CITY OF ALBUQUERQUE

March 24, 2016

**Re: Signal Pointe Subdivision at Signal/Ventura (C20D070)
Grading and Drainage Engineers Stamp Date 9/15/2015
Engineer's Certification of Scour Wall dated 3-17-16**

Based upon the Certification received 3/18/2016, the As-Built Certification of the scour wall is not accepted for the following reasons:

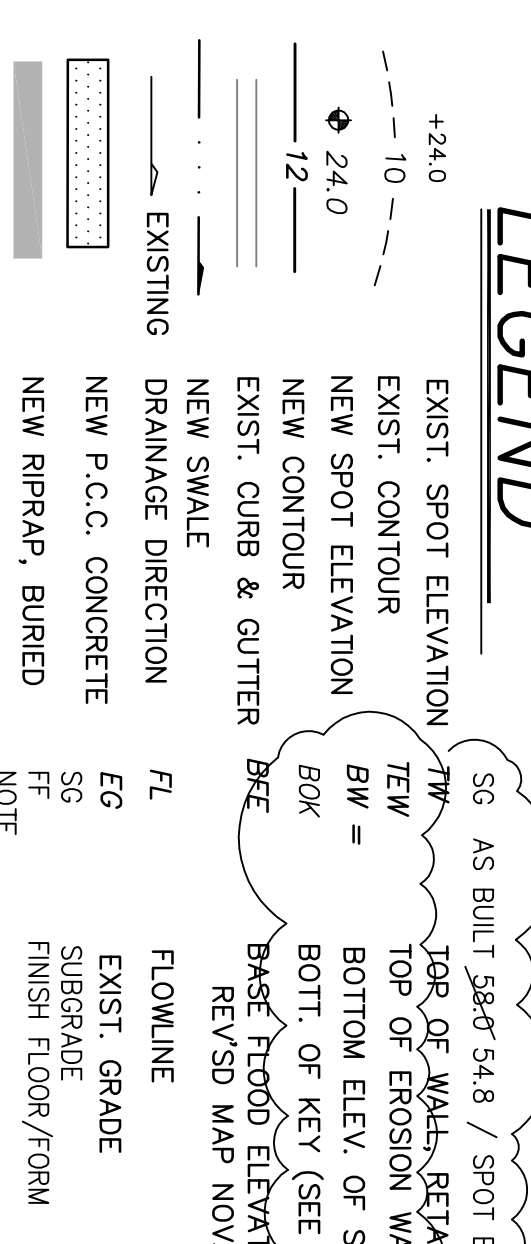
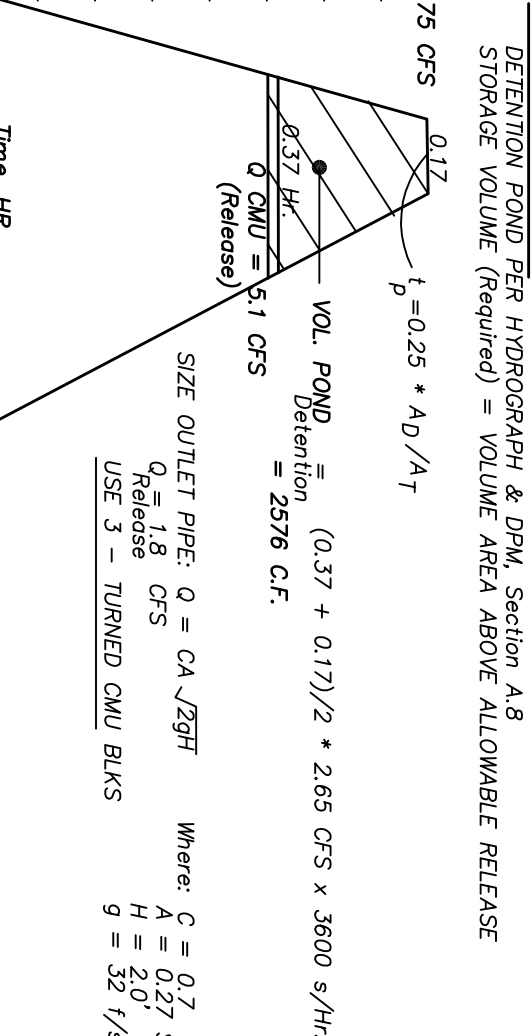
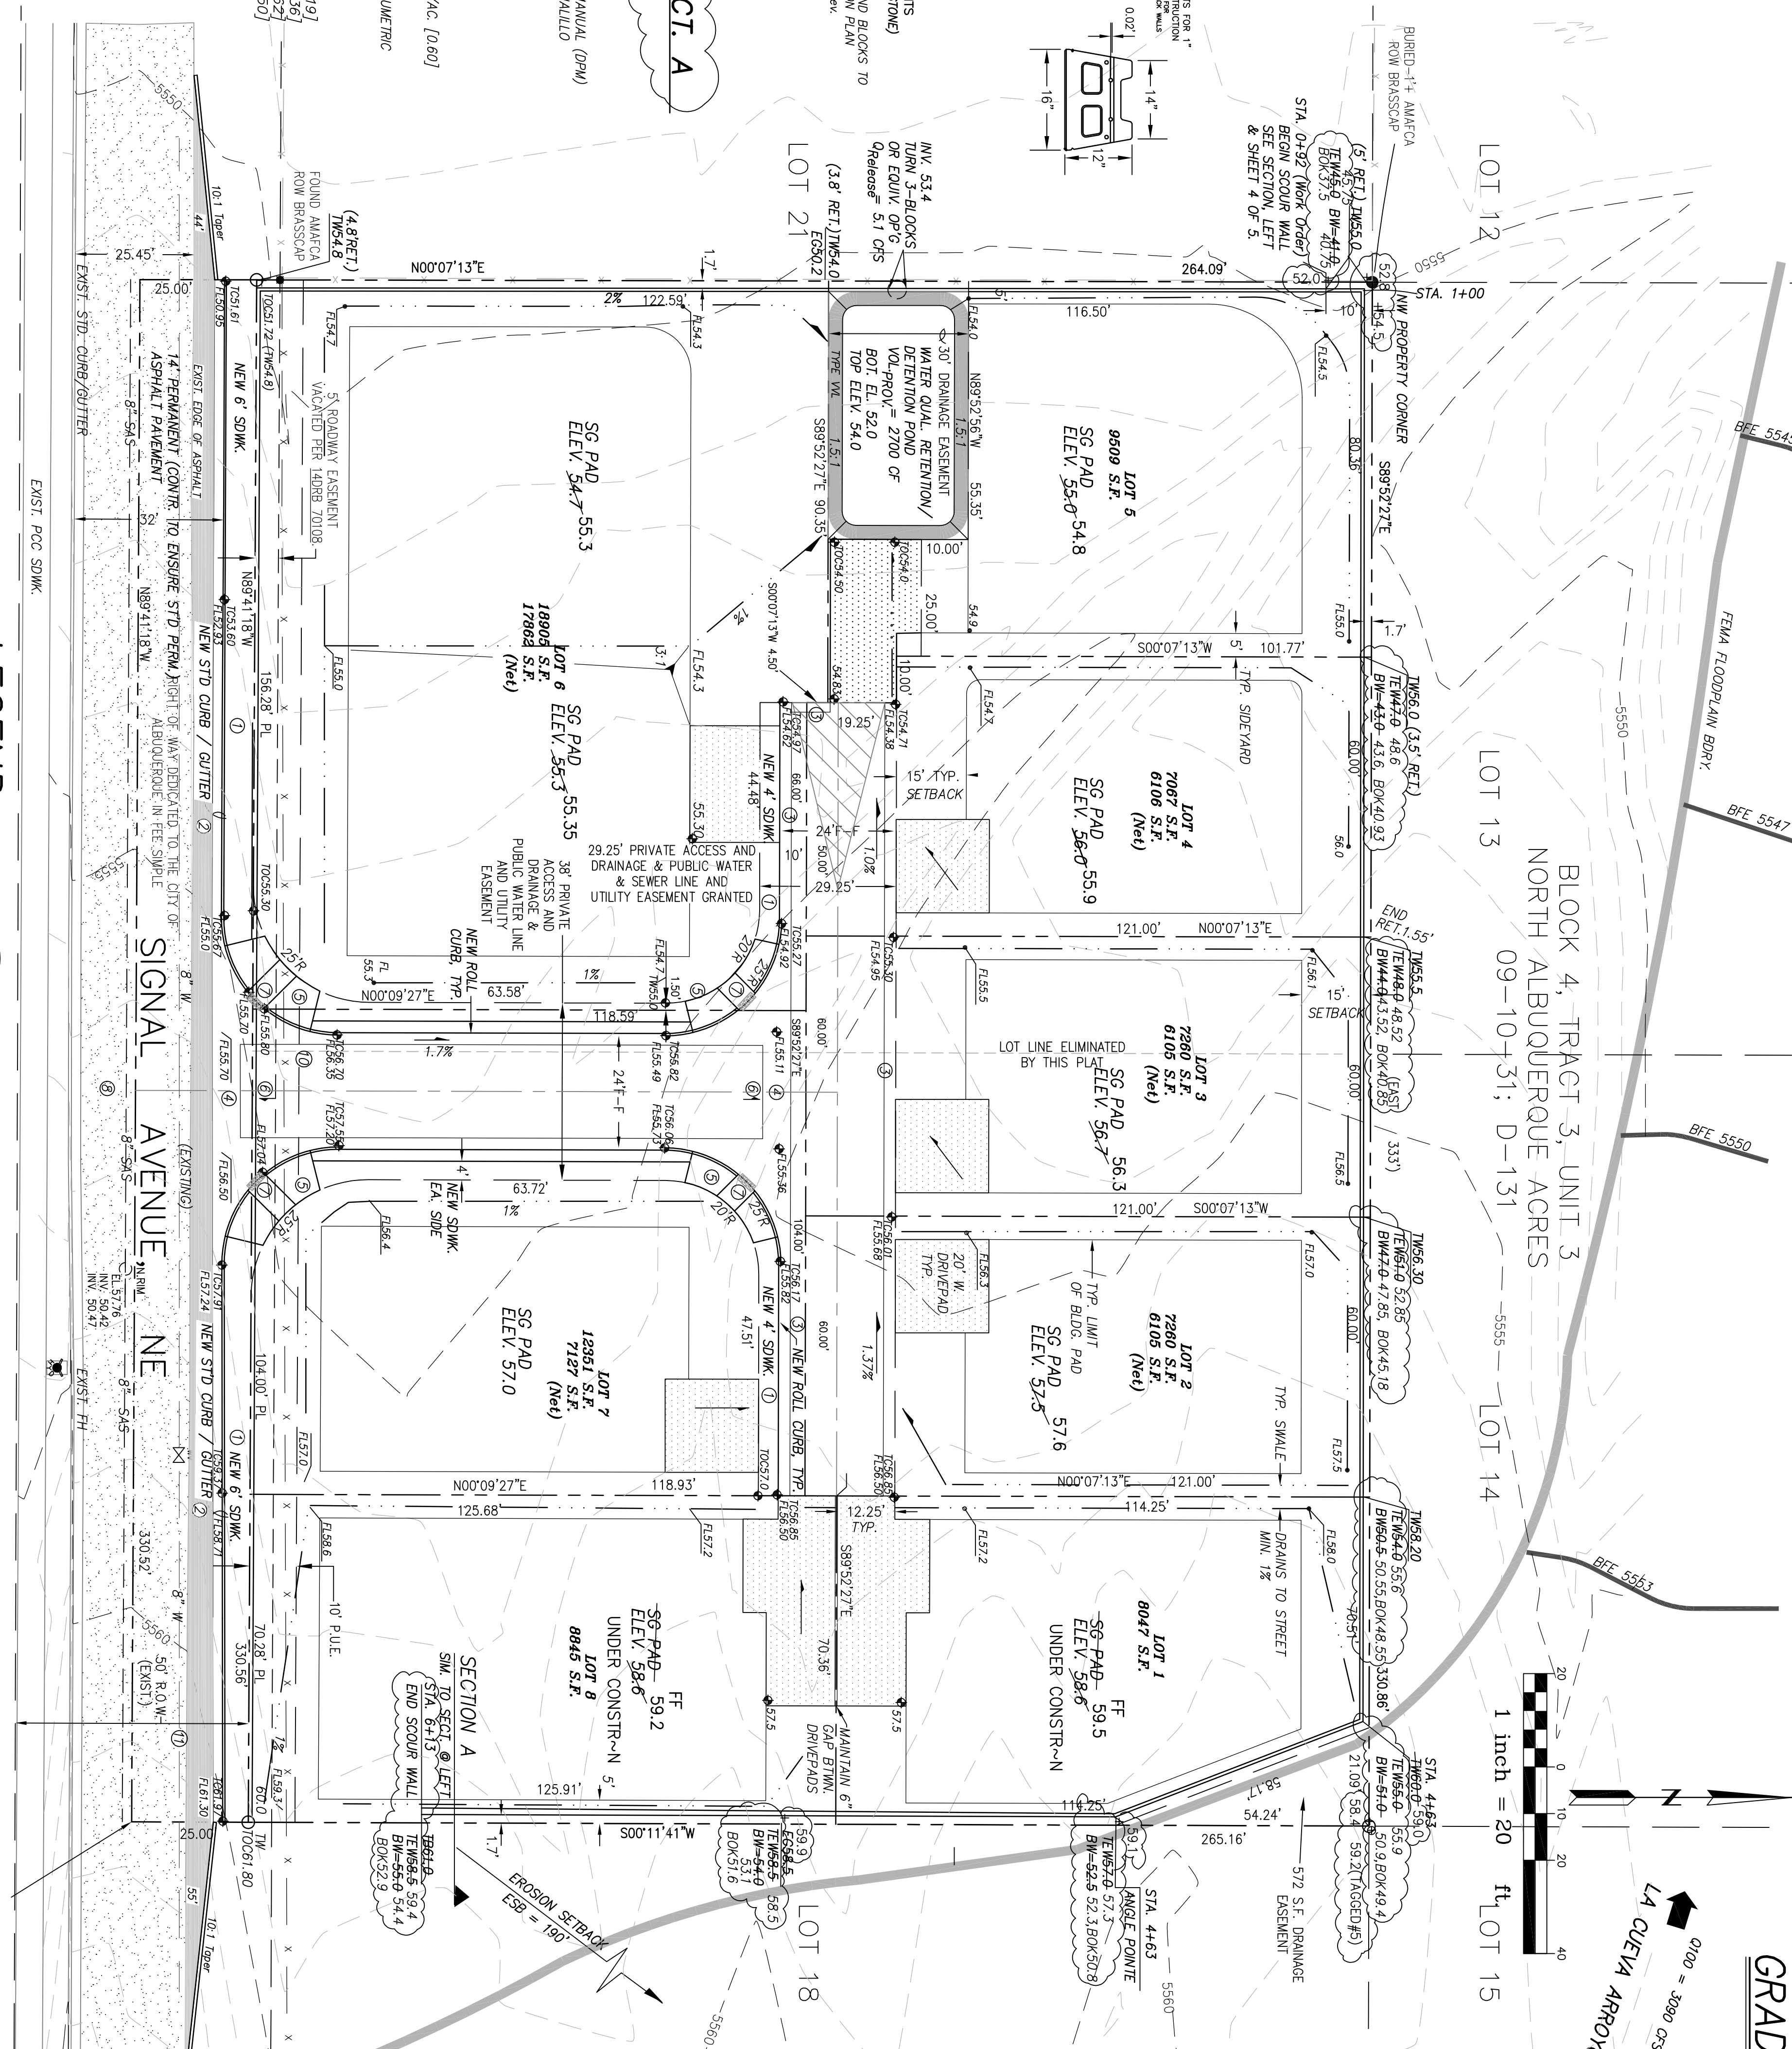
- Approval of the Grading Plan was conditional upon you providing wall details, calculations, and specifications. Only wall sections were submitted to Hydrology.
 - Wall sections do not show the scour line limits
 - The key has no reinforcing and with the 2' length dimension shown, significant reinforcing would be expected in a key of that length.
 - **Structural Calculations for the wall need to be provided.**
- Site inspection shows that the middle portion of the wall along the northern boundary is incomplete. Furthermore, there were 16" pilaster blocks sitting on top of 12 in wide CMU blocks with cells open to the dirt. **Structural Engineer responsible for the wall design should perform a site visit and provide an Engineer's Certification of the wall (not the Civil Engineer)**
- Fill and CMU debris were in the natural channel.
